Cumberland Bird Observers Club

29 July 2012

Submission against the Newcastle Coal Infrastructure Group Coal Export Terminal Rail Flyover Modification Stage 2F (MP 06_0009 MOD 2), June 2012

The Kooragang Island Main Line inbound track realignment is shown on Figure 3.

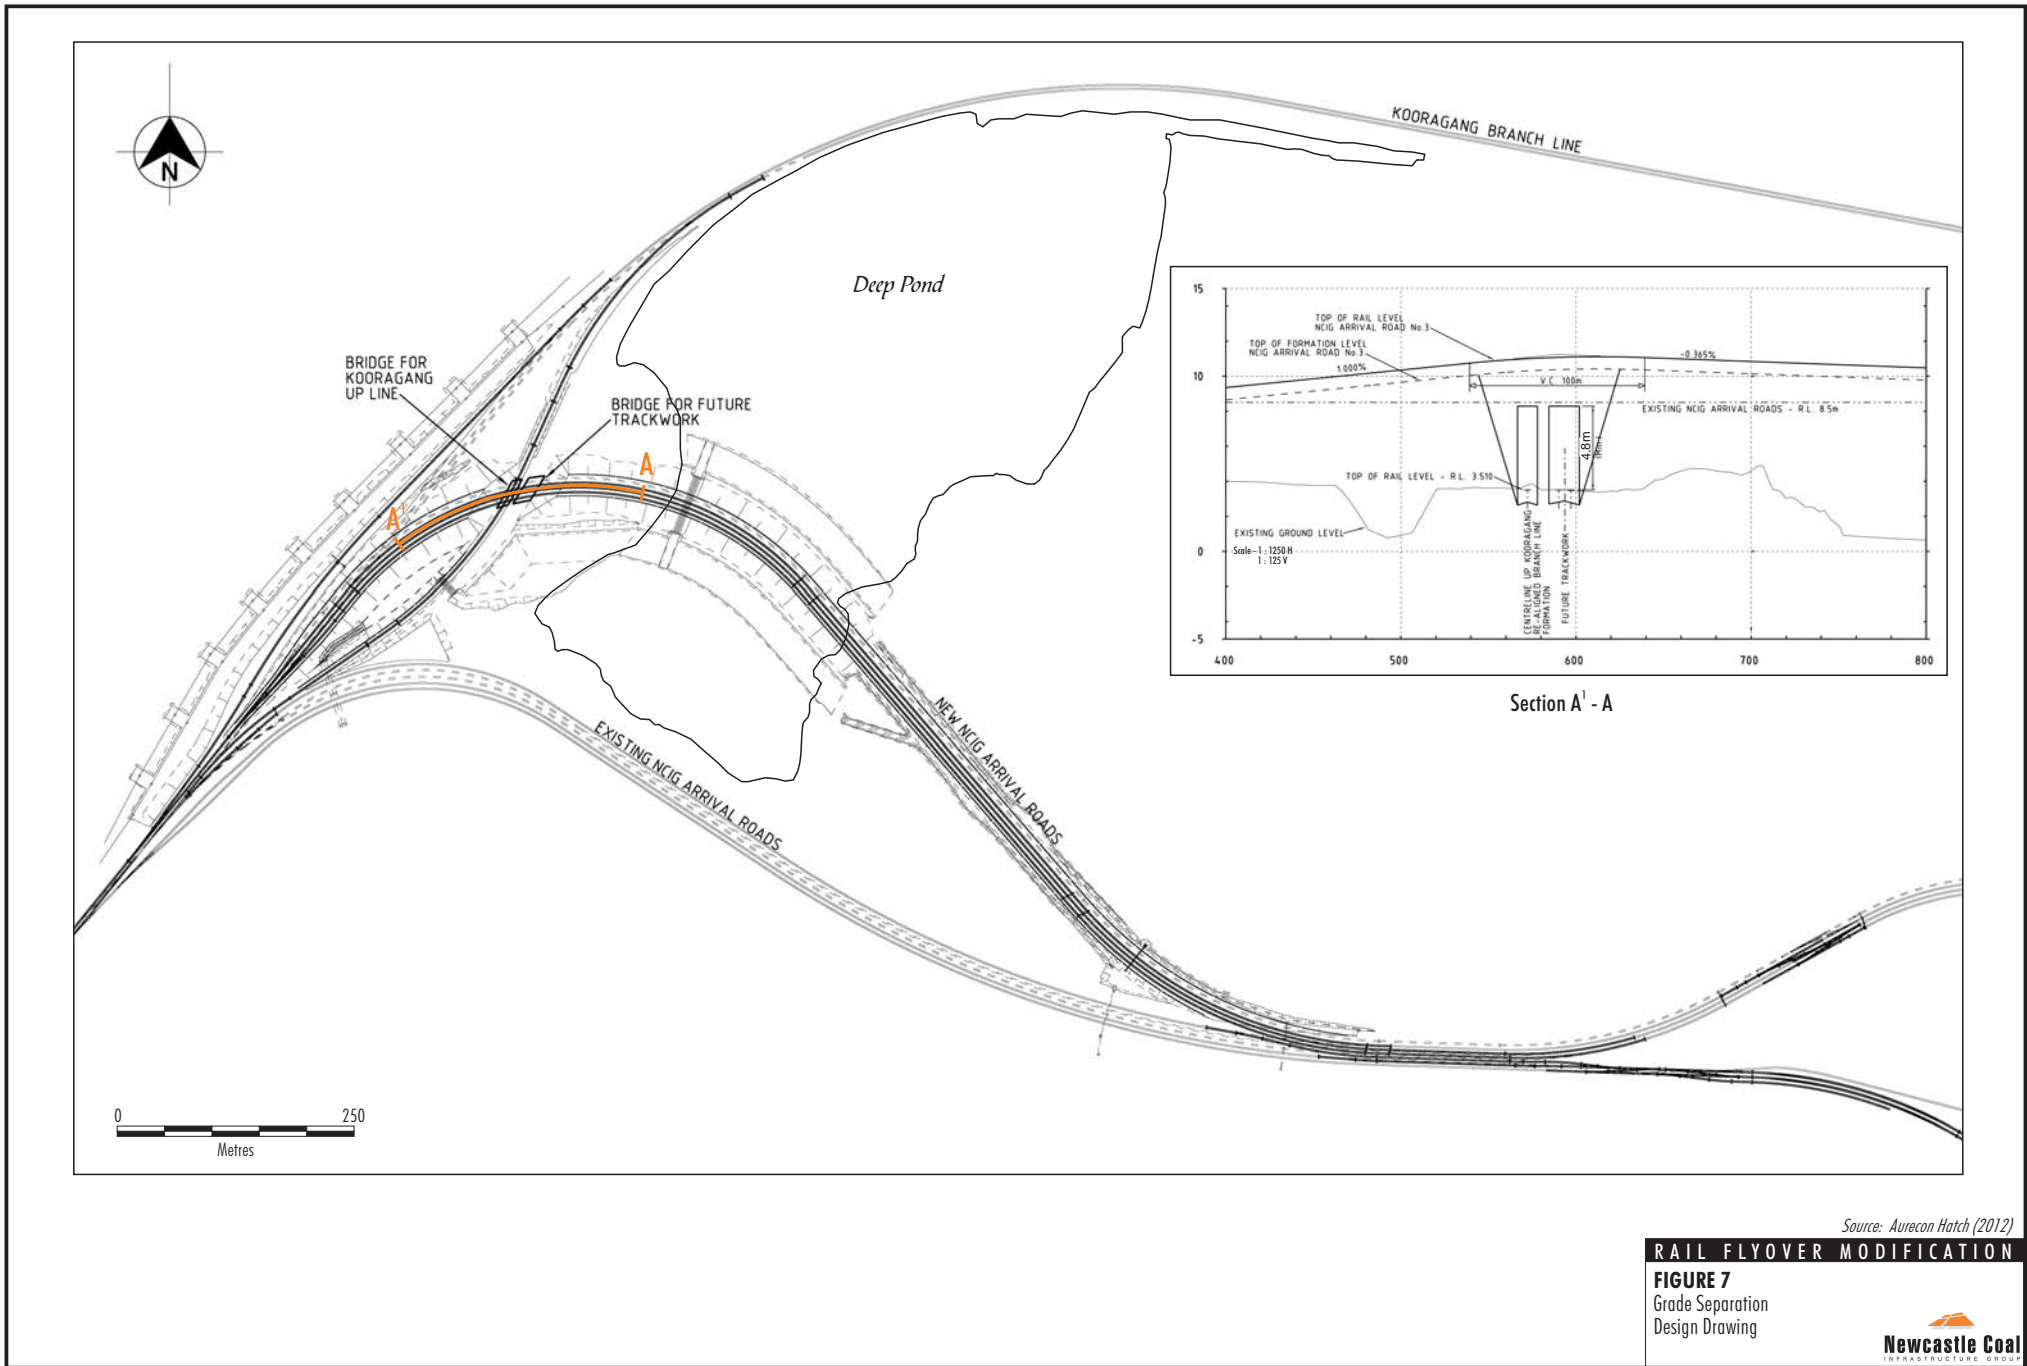
CBOC understands the RFM project would destroy shorebird habitat in Swan Pond, along the shallow shore for about 790 metres x 50 m (an area of c. 4 ha) parallel with the Kooragang Island Main Line, and during construction an even larger area would be impacted, with widespread disturbance of birds.

The proposed rail tracks for the NCIG Flyover project will be constructed adjacent to Port Waratah Coal Services' Terminal 4 project (T4) railway tracks, which themselves would impact further on Swan Pond. Between them these two projects would essentially destroy the southern end of Swan Pond and seriously damage the northern section.

The impact of the rail realignment is referred to as "minor", although it is likely to dump 360,000 tonnes of fill in and near Swan Pond. The EA erroneously states that "habitats impacted by the

FIGURE 4

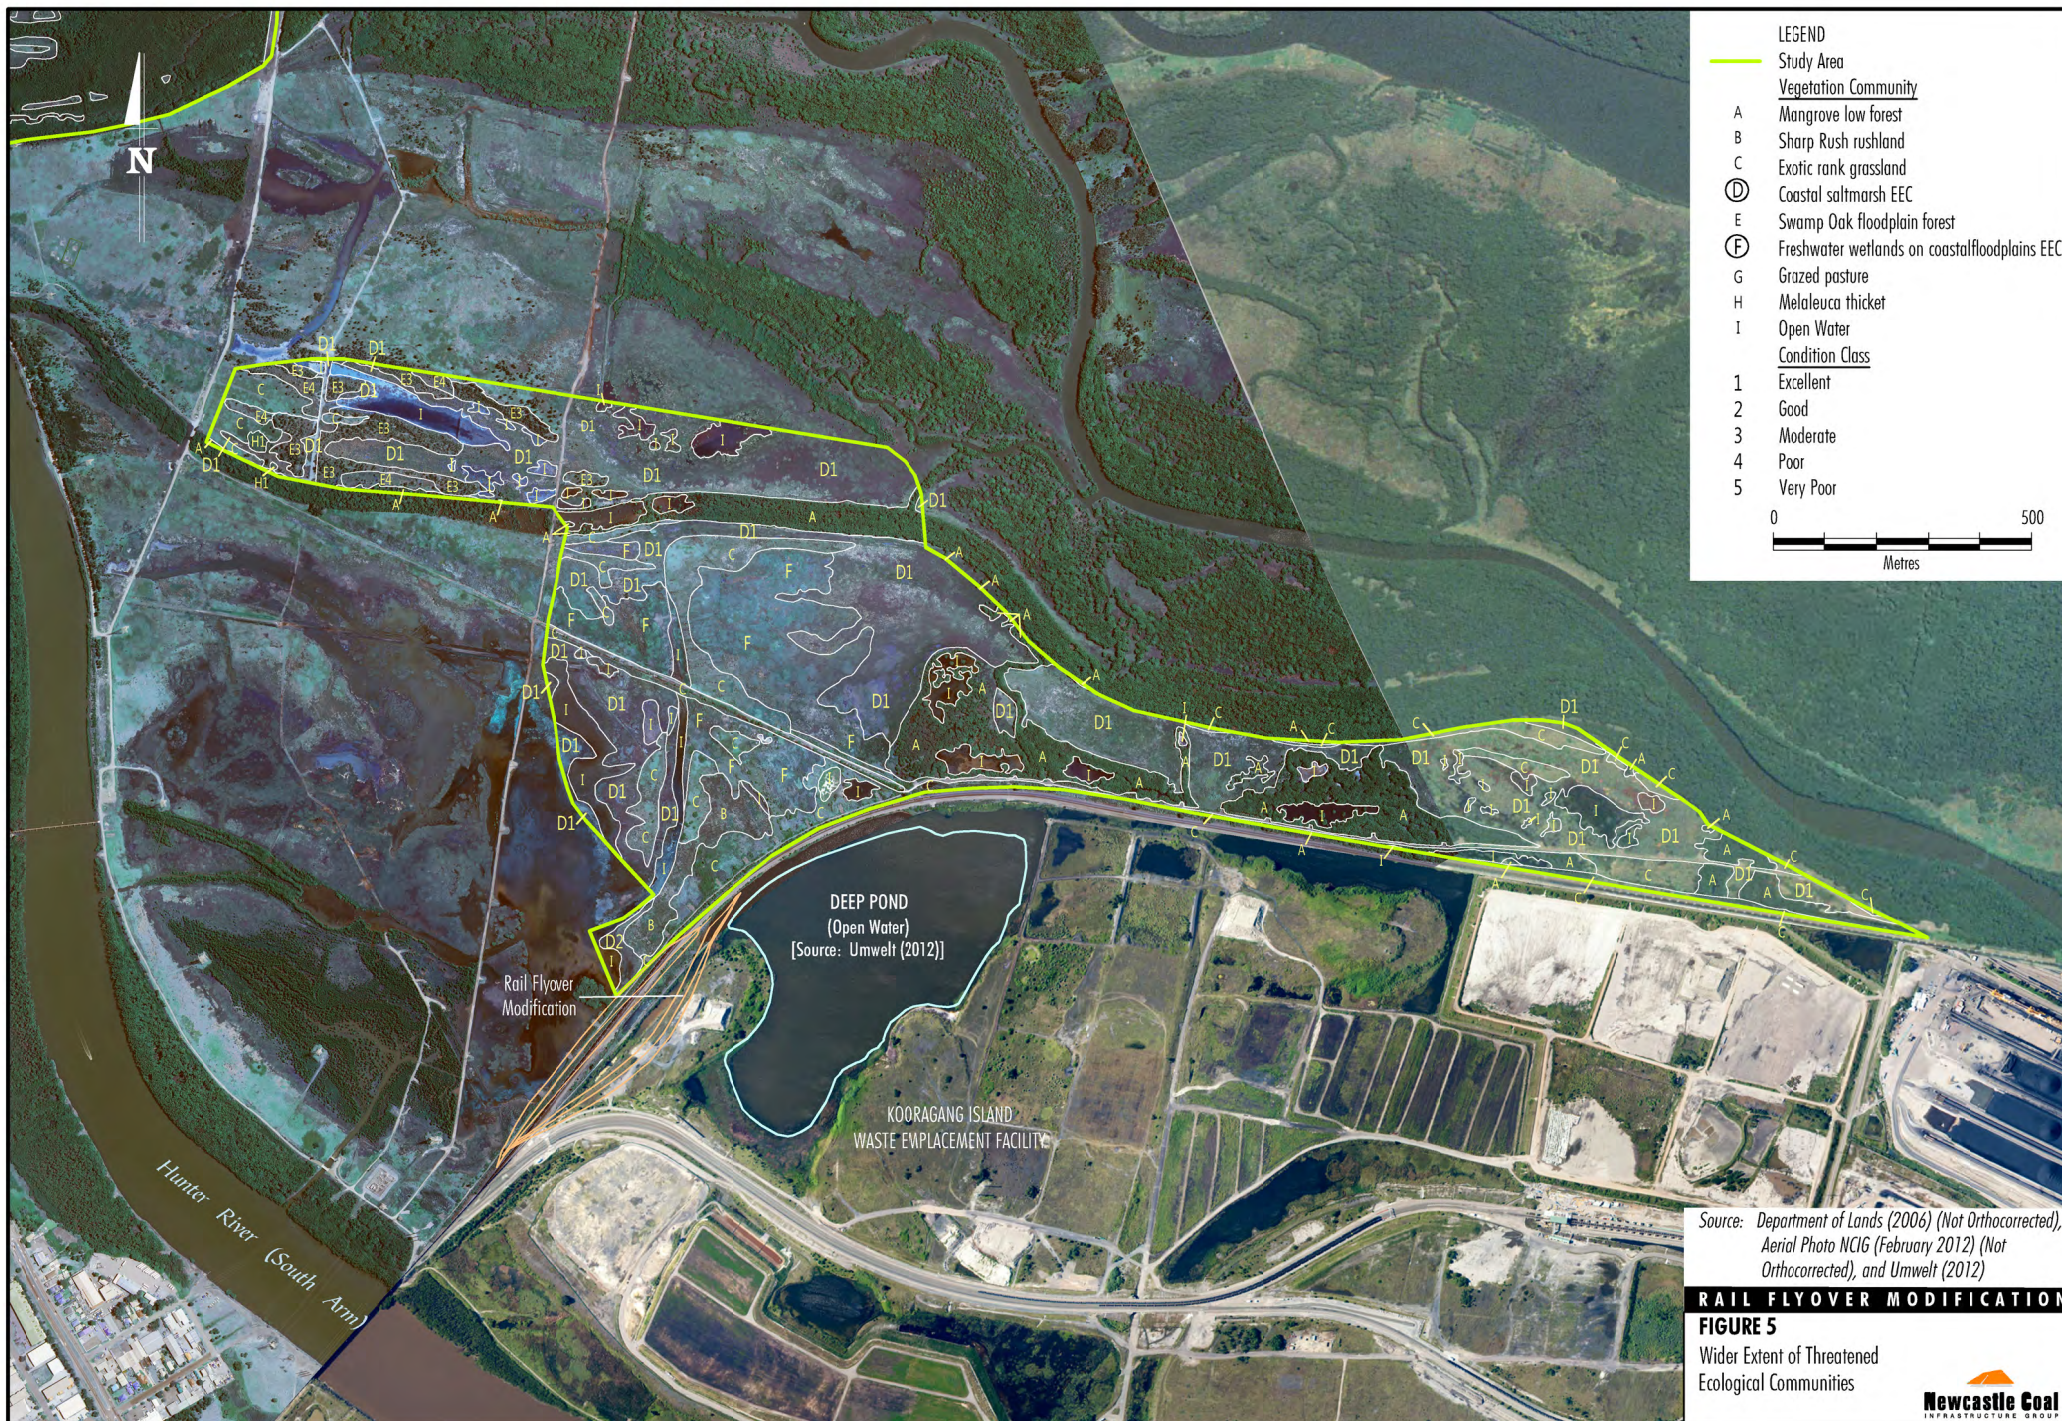
The EA does not even recognize Swan Pond as an important wetland, instead vaguely (and deceitfully) referring to it as "additional lands" or "1.4 ha of land adjacent to the Kooragang Island Main Line". This Pond has been widely recognized as important shorebird habitat since the 1980s and was named in the early 1990s; it appears on maps of the area.

The EA relies on inadequate “desktop studies” and a single survey in 2012, rather than on long term field survey data. There was no investigation of which bird species forage and roost in the areas of Swan Pond to be destroyed, and which species might be excluded from the whole area by disturbance of part of it, which would be necessary to judge the true impact of the habitat destruction. The EA includes a general table of “Threatened Fauna Species ...” which contains bird species not normally found on Kooragang Island but omits several shorebird species listed under the EPBC Act. The evaluation of impacts on species is superficial, and an inadequate basis for assessing the environmental implications of the project.
